**21/03268/OUT**

Proposal: Outline planning permission (all matters reserved except for access) for the erection of buildings comprising logistics (Use Class B8) and ancillary Office (Use Class E(g)(i)) floorspace; construction of new site access from the B4100; creation of internal roads and access routes; hard and soft landscaping including noise attenuation measures; and other associated infrastructure

**21/03267/OUT**

**Objection:**

Drawing Title: **PARAMETER PLAN 08
VEGETATION RETENTION
& REMOVAL**

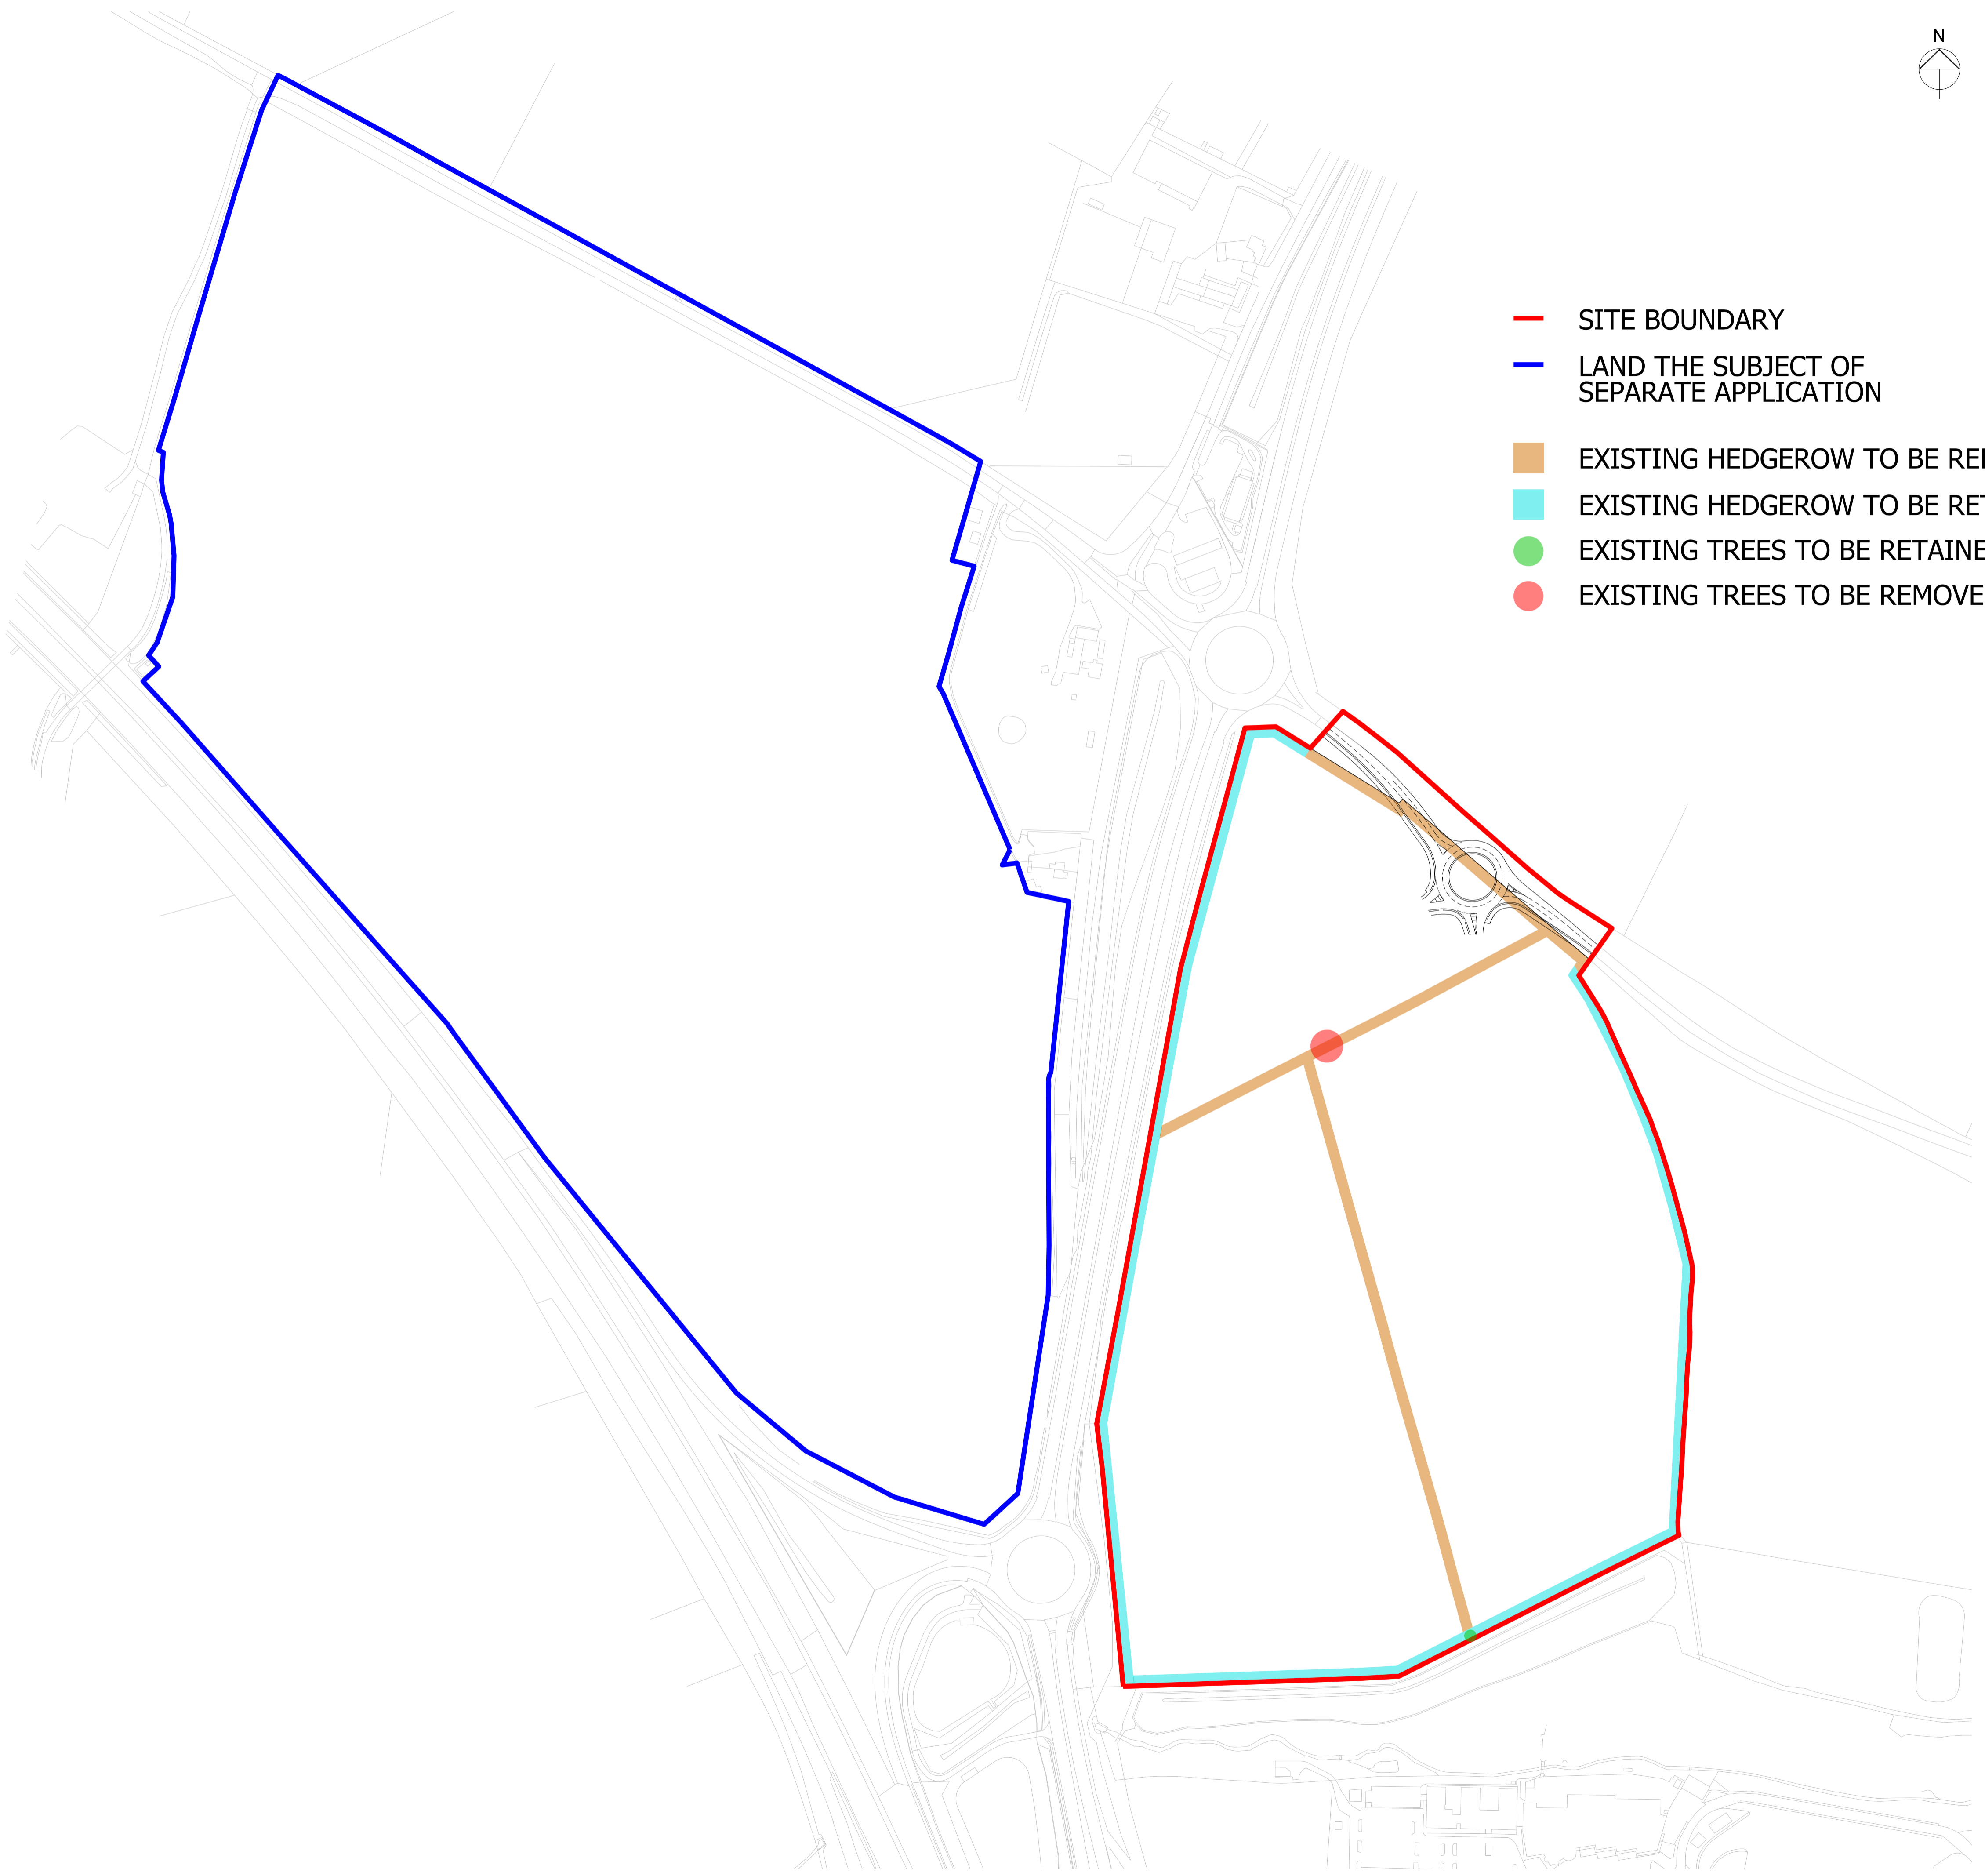
We are greatly concerned by the significant loss of wildlife habitat that this development would lead to with the current design. The ecological survey describes significant areas of priority habitat hedgerow within the site e.g.

*“Construction will require the removal of the defunct species-poor hedgerows within the centre of the Eastern Site, H12 and H13”.*

*“Construction will require the removal of the defunct species-poor hedgerows within the centre of the Site, H3, H4, H5 and H6.”*

We do not accept that the benefits of the development outweigh the harm it would cause to the site in relation to the loss of hedgerow and we do not accept that the mitigation proposed will achieve a net gain in biodiversity (see below). In addition, ecological networks provided by the hedgerows will be fragmented as a result of the development and for these reasons we believe the development would be contrary to Policy ESD 10 of the local plan which states that *“ecological corridors should form an essential component of green infrastructure provision in association with new development to ensure habitat connectivity”* (see above).

Drawing Title: **ILLUSTRATIVE TYPICAL ELEVATIONS**

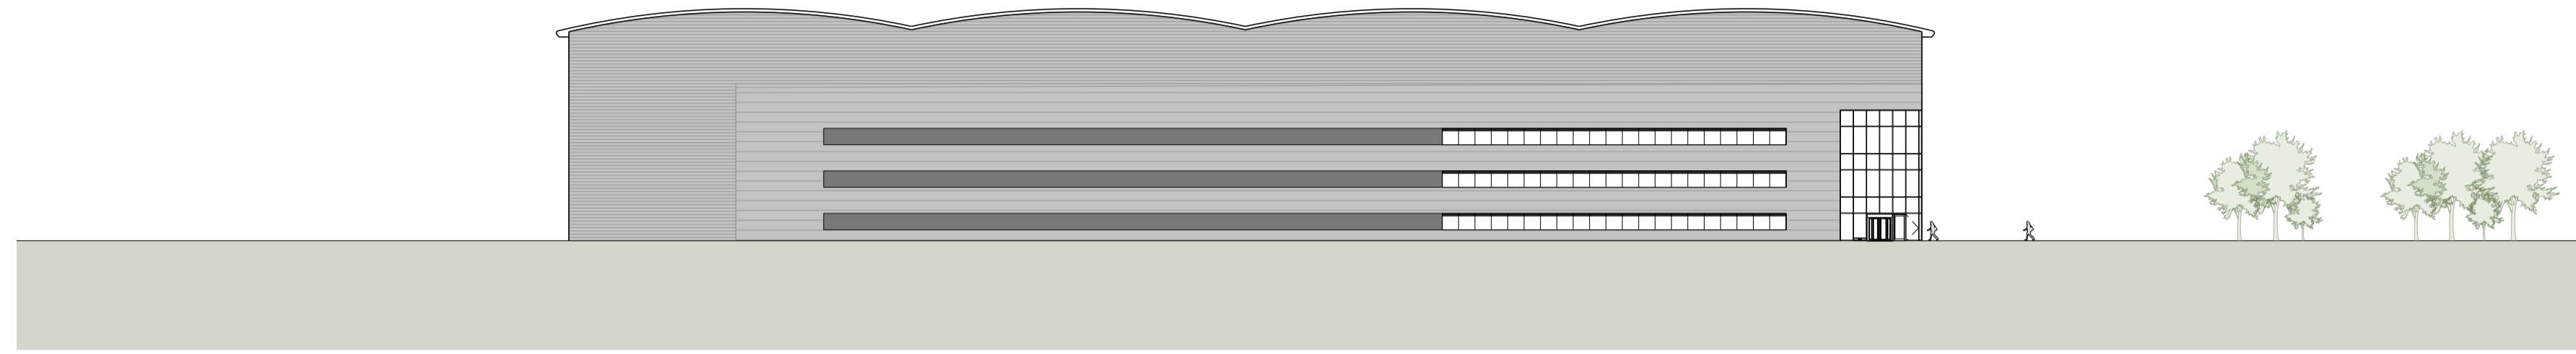
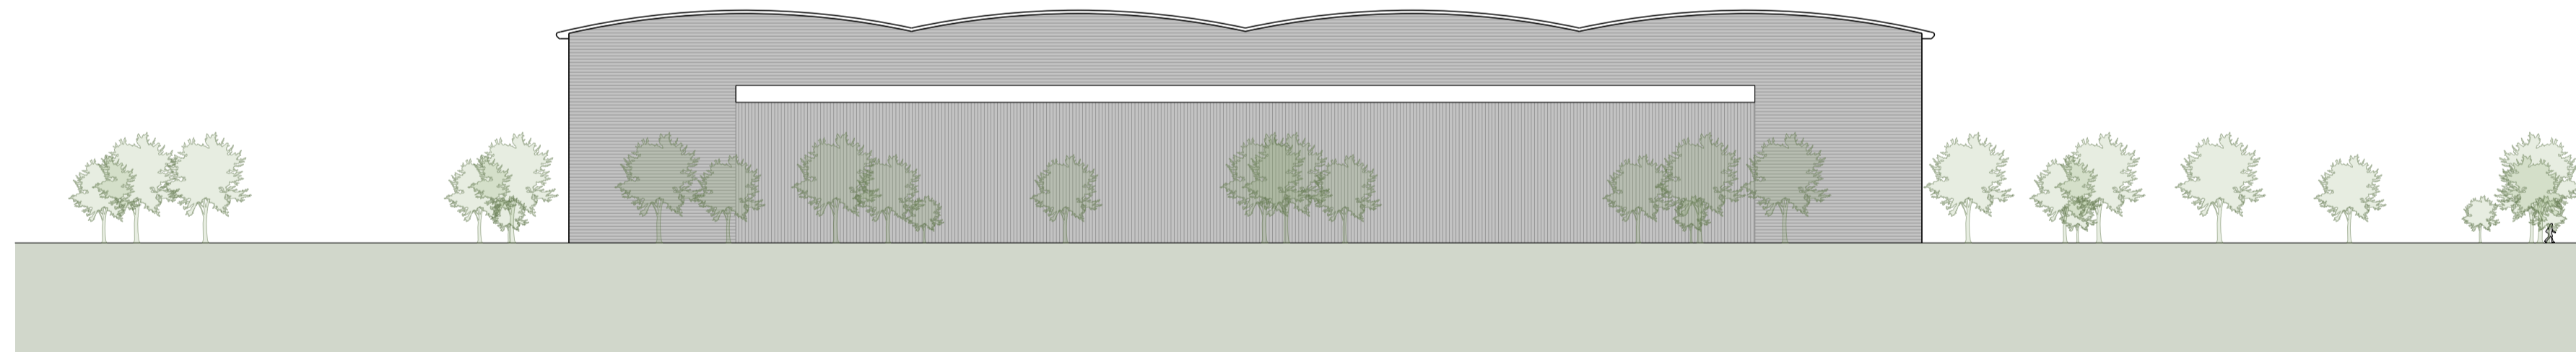
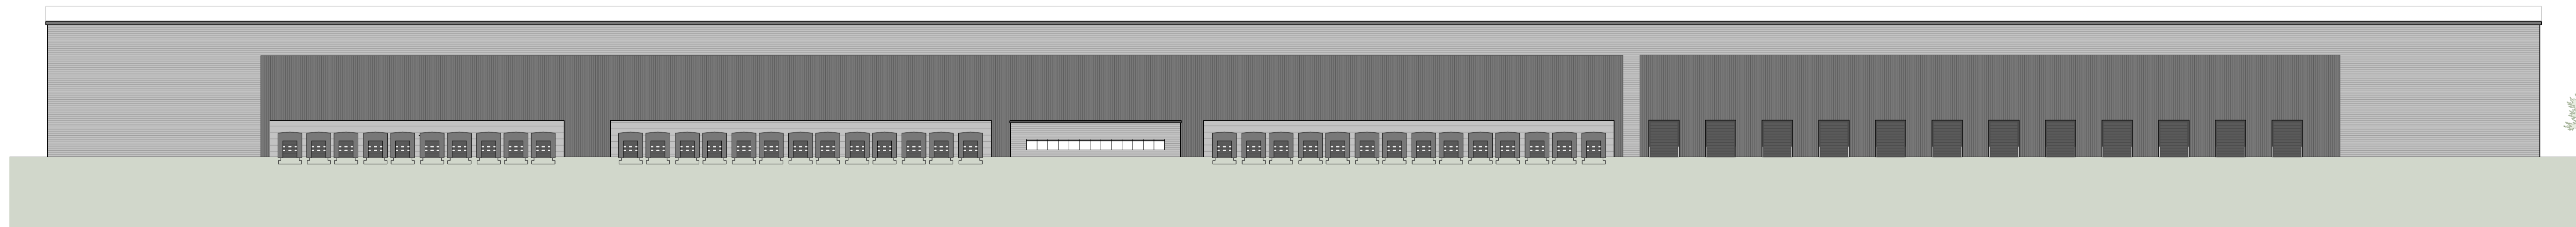
Given that we regularly see applications for solar panels in fields, we believe that in order to make most efficient use of available space, much needed solar panels should be included on the roofs of large buildings wherever possible. If the local authority decides to grant permission for this application, we consider that the applicant should be required to include solar panels on the warehouse roofs, in addition to the mitigation measures set out above.
